STOP GREEN HILL SOLAR

SUMMARY OF ORAL SUBMISSIONS TO ISH-2

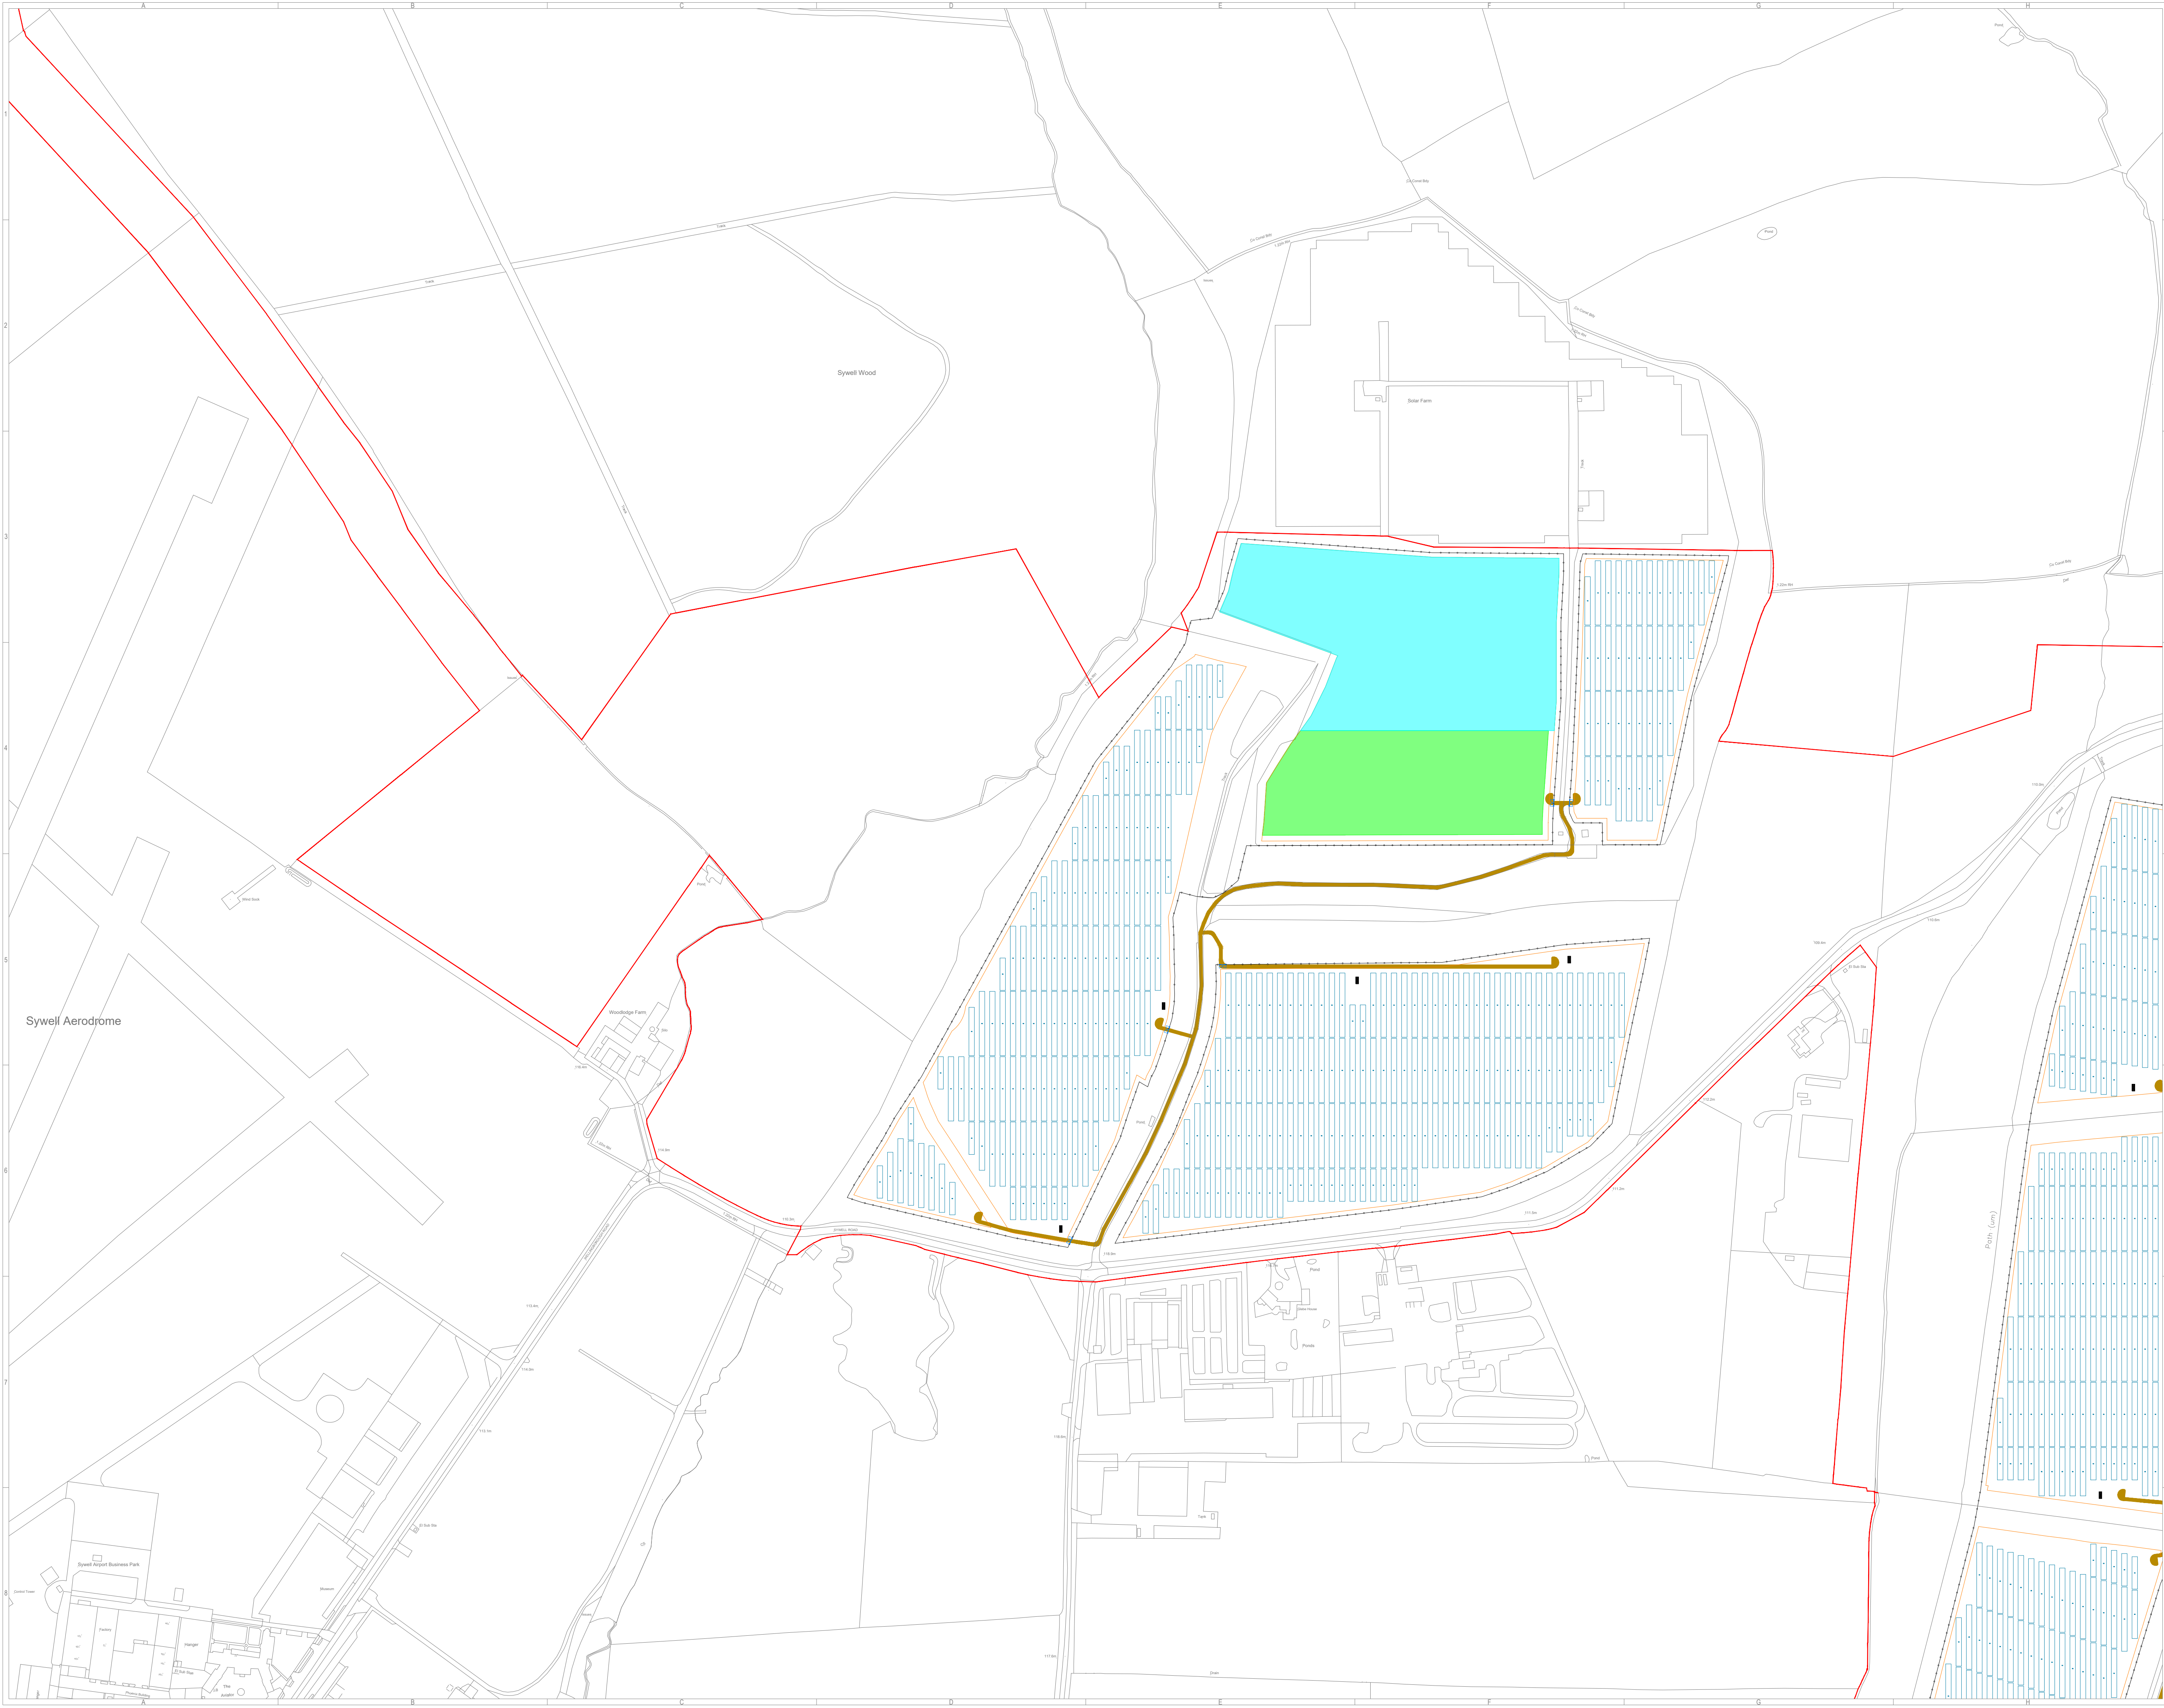
4. The indicative layouts of the BESS are very vague. There would be in excess of 500 containers that will be arranged in groups of four. The spacing between the containers is not specified. From the drawings² the spacing between each container within a group of four will be about one metre. The spacing between the clusters might be between 5 to 10 metres but there are difficulties measuring off such small scale plans. There is a lack of detail and clarity.

8. Reference is made by the applicant to fire/plume tests conducted by Wartsila in Ohio in 2023. However, this is not peer reviewed. And it assumed that the fire was contained to one container. Here, the plans show containers very close together so there is a concern that a fire in one (temperatures could reach over 900 degrees C) could spread to other containers. This is where the lack of UK standards really shows up because we don't have any condition for the developer to supply a particular type of BESS container with all these thermal barriers built in between the modules, and between the module and the container itself. So, there's real inadequacies here. It's been left to the supplier of the BESS units.

13. Professor Dobson has referred to Option A, for which the layout there shows some 550-odd containers, some of them being only a metre apart. That does not seem to meet any category of minimum guidance for spacing. So, one has to ask, if in due course, when the HSE or the National Fire and Rescue Service are eventually asked for their views, they require greater spacing between containers, there would not be sufficient space at the Grendon BESS. The option then is also for a BESS site at Site C which appears only to have one access point.
